State Significant Development Application and Variation of the Sydney Cove Redevelopment Scheme for the 'Remediation, Renewal and Adaptive Re-Use of Campbell's Stores', The Rocks (SSD 7056)

My second submission is an objection on **HERITAGE** grounds in relation to:

Drawing Title  
**ELEVATIONS**  
JPW Project Number  
12006  
Drawing Status  
EA  
Drawing Number  
EA-A-2000  
Revision  
B

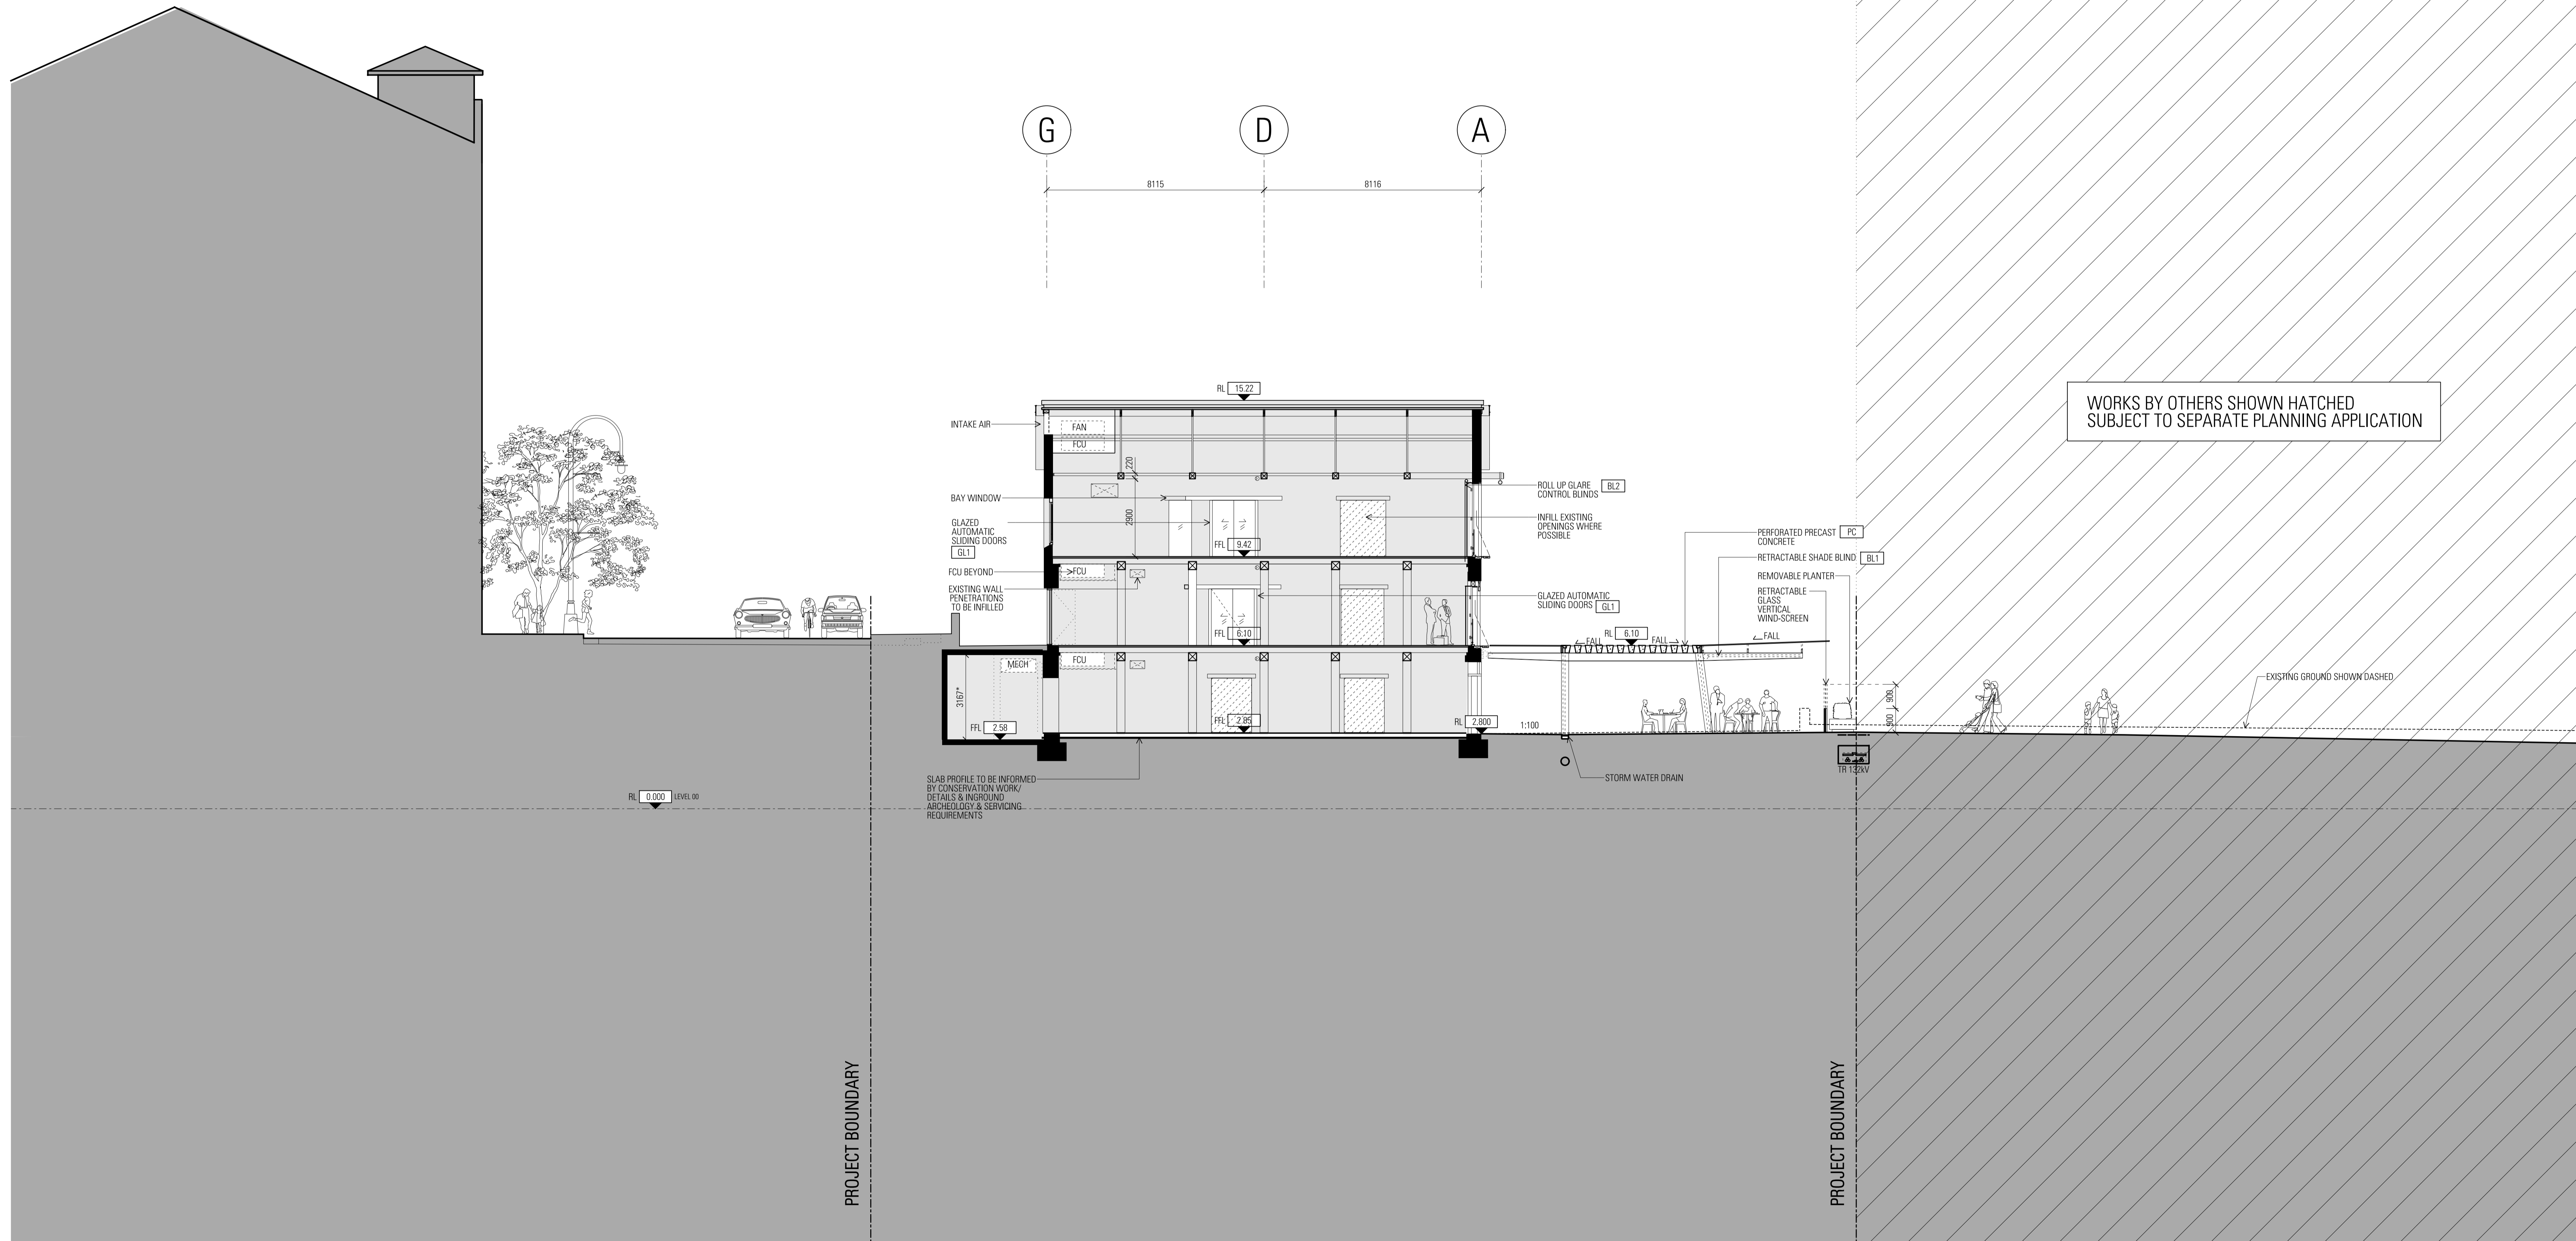
- widening of the existing c.1915 openings on the Hickson Rd frontage to create three new and much larger concrete entry portals. Creating these openings will destroy sections of the building's early sandstone brickwork and the end product will encroach upon the City of Sydney's existing pedestrian footpaths. The openings will all have back-lit signs and the centre opening will cut right through the building further damaging its original fabric.

- the creation of outdoor eating areas, with chairs, tables and umbrellas on Hickson Rd. While this is an appealing image, it would reduce visibility to this (western) side of the Stores and limit people's opportunity to appreciate the building's original form and function. This western elevation is the side that is most in keeping with the original form of Campbell's Stores and the one that most reveals the Stores' 19th century character. To maintain its heritage significance, this façade needs to be kept intact as much as possible.

- the removal of the existing awnings and canopies adjoining the eastern elevation of the Stores. This is the elevation that faces the foreshore and the Opera House so removing these intrusive elements would reveal the building they currently hide. However, this improvement would be short-lived. The applicant wants to replace the old intrusive elements with new ones - stand-alone canopies that feature perforated precast concrete roofs. These are not transparent and so will prevent the public having clear views of the eastern (foreshore) side of Campbell's Stores.

- appreciate this heritage building,
- the creation of two new openings in the south elevation and the closure of one of the heritage openings. This will be a missed opportunity to reveal this elevation in its original form and a further blow to the building's heritage significance.
- the contravention of a large number of policies within the Campbell's Stores Conservation Management Plan (CMP), which SHFA commissioned and which the Heritage Council endorsed in July 2014, only 18 months ago. These include:

- The glass building would comprise three levels sitting on four columns. It would have the appearance of a tall and bulky glass box on stilts and would obscure all of the Stores' northern elevation. Its minimal 2.5 metre undercroft would be oppressive and tunnel-like and this, along with its intended use for outdoor eating, would serve as a barrier, limiting public access to the foreshore and severely constraining existing views to the Opera House from this location.

- The proposed glass box would be located next to Bay 11 on the northern elevation of Campbell's Stores. When measured from the proposed new ground level, it would be 13.3 metres high with the inclusion of its 1 metre high lift overrun. This exceeds the height restriction on the foreshore frontage by 14.5m, more than 250% and on the Hickson Road elevation by 10.5m, or 140%. This would require a significant spot re-zoning under the

- The proposed new ground level would be 1.94 metres higher than the existing one so as to accommodate a basement area. Contrary to claims that there would be a four metre setback between the two buildings, the basement level of the glass box would abut the Stores and effectively bury the ground floor of the Stores' 'Highly Significant' northern façade almost to the tops of its existing windows. This is shown very clearly in the following sections of JPW's Design Statement – the northern elevation profile (p.96,) the Concepts diagram (p.102) and the Bay 12 'adistic imdression' (artistic impression?) listed for the 4th of the series of 'Day 12' (Bay 12?) images. (no page number given). The 5th 'Day 12' image on the following page omits showing the upper section of the windows. It therefore misleads the reader as to the significant extent to which the raised ground level 'buries' the northern elevation of Campbell's Stores.
